Phone: 0300 123 6780
Email: developeras@lancashire.gov.uk
Your ref: 3/2025/0729
Our ref: 3/2025/0729/HDC/KW
Date: 16 December 2025

Location: Oak Lea Osbaldeston Lane Osbaldeston BB2 7LT
Proposal: Proposed two-storey replacement dwelling.
Grid Ref: 364839 432109

The Local Highway Authority (LHA) are in receipt of an application for the proposed two-storey replacement dwelling at Oak Lea, Osbaldeston Lane, Osbaldeston.

title
Proposed Garage
Plans and Elevations

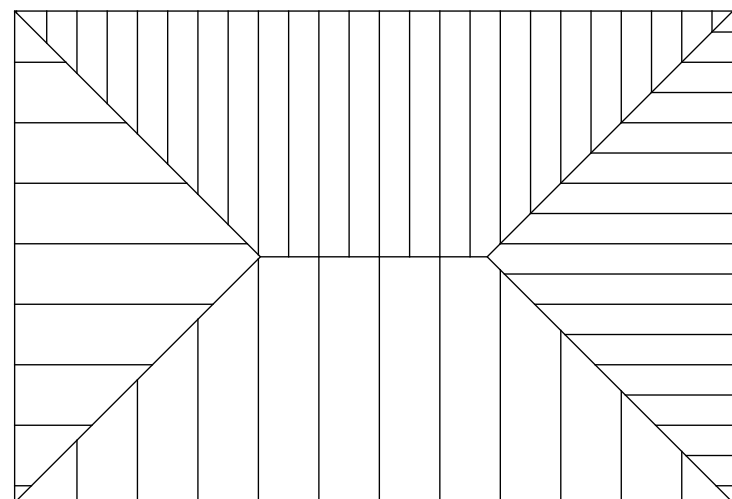
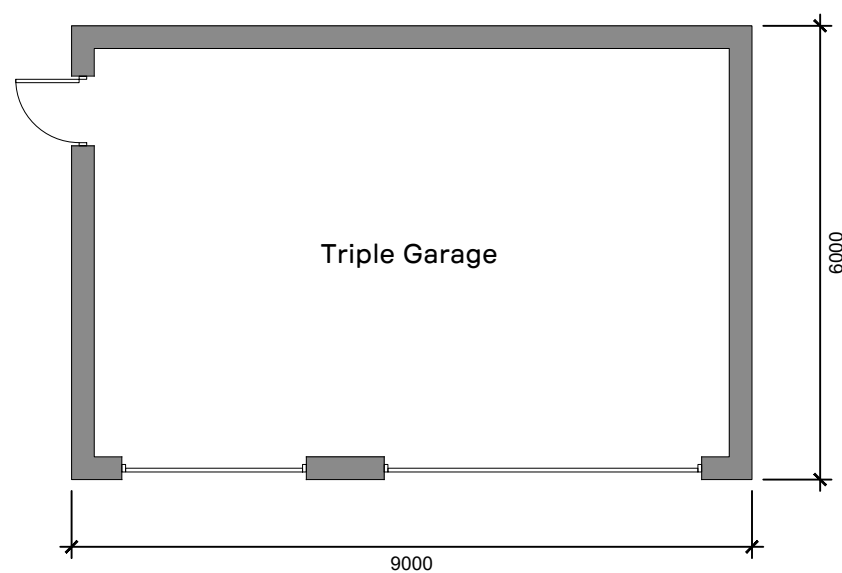
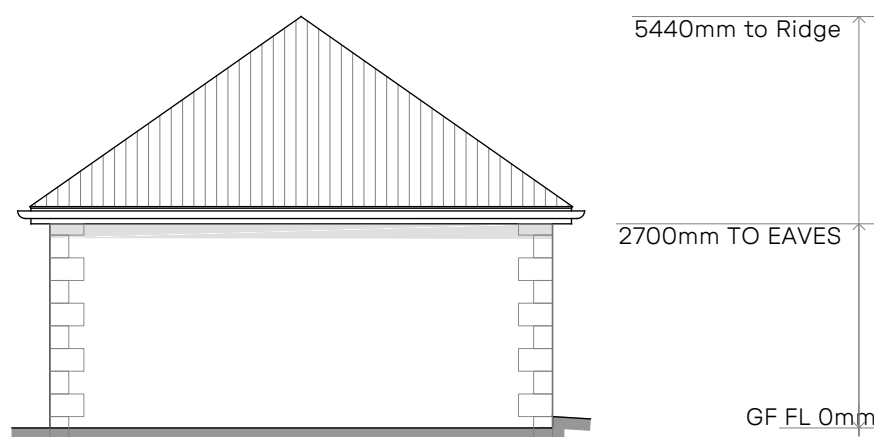
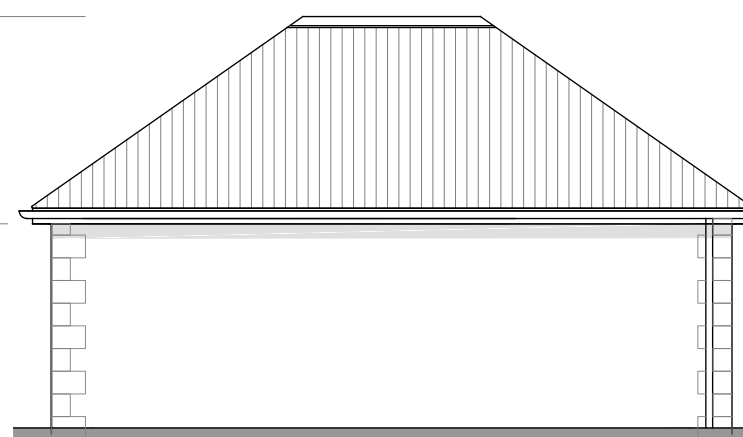
The LHA has reviewed the internal layout of the proposed garage. The recommended minimum internal dimensions for a triple garage size is 6m in length and 9m wide. The recommended distance of 6m in length is based on the length of a large family car (Ford Mondeo Estate 4.58m long), clearance at the rear of the car (200mm), overhang of the garage door (600mm) and room to stand in front of the car and open/close the garage door (600mm). As the proposed garage is approximately 5.5m in length, it cannot be considered to provide off-street parking provisions. However, the garage can provide acceptable cycle storage provisions.
